Cadia Valley Operations – MOD 13 Cadia Hill Tailings (PA 06_0295): Adequacy of the Environmental Assessment (EA)

I refer to the email dated 19 September 2019 inviting the Resources Regulator to provide advice regarding the adequacy of the Environmental Assessment (EA) for Project **Cadia Valley Operations**.

Figure 2: Proposed Modification Layout

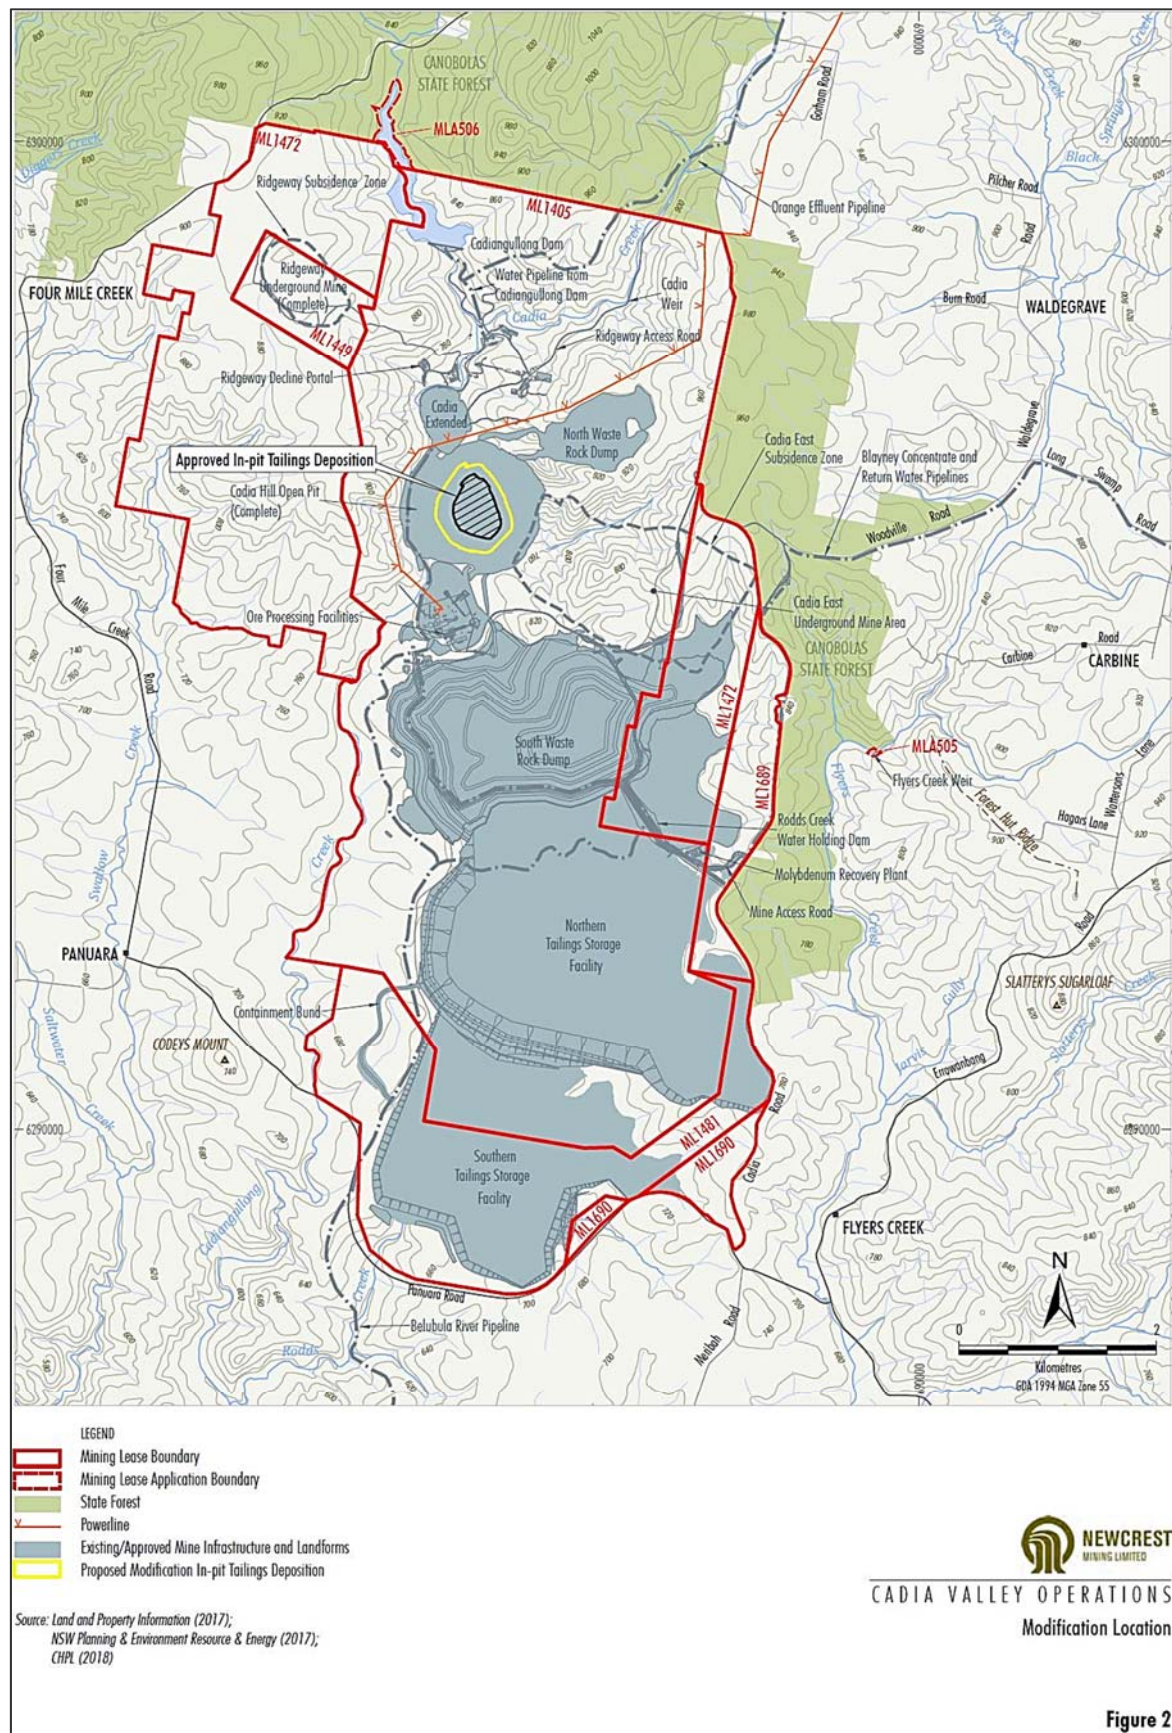
The Resources Regulator advises the Department of Planning, Industry & Environment – Resources Assessments that the Environmental Assessment does not adequately address Rehabilitation of the Cadia Hill Pit tailings. As such, the additional information is required to address the uncertainty of how long a pit lake will take to develop over the consolidated tailings and how the tailings will be managed in the interim period of time. The assessment indicates that the pit will become a 'sink' within 6-7 years when tails subside to below 700mAHD. However given the low permeability of the surrounding geology, a period of time of >150 years for groundwater levels to stabilise at 687-699mAHD has been modelled.

Based on this uncertainty, the proponent is required to describe how exposed tailings will be managed in the interim period following closure until the the development of a water cover within the pit. For example, will this require the construction of an interim cover/cap over the tailings? If so, what will be the options and associated strategy for construction for tailings cover / cap.
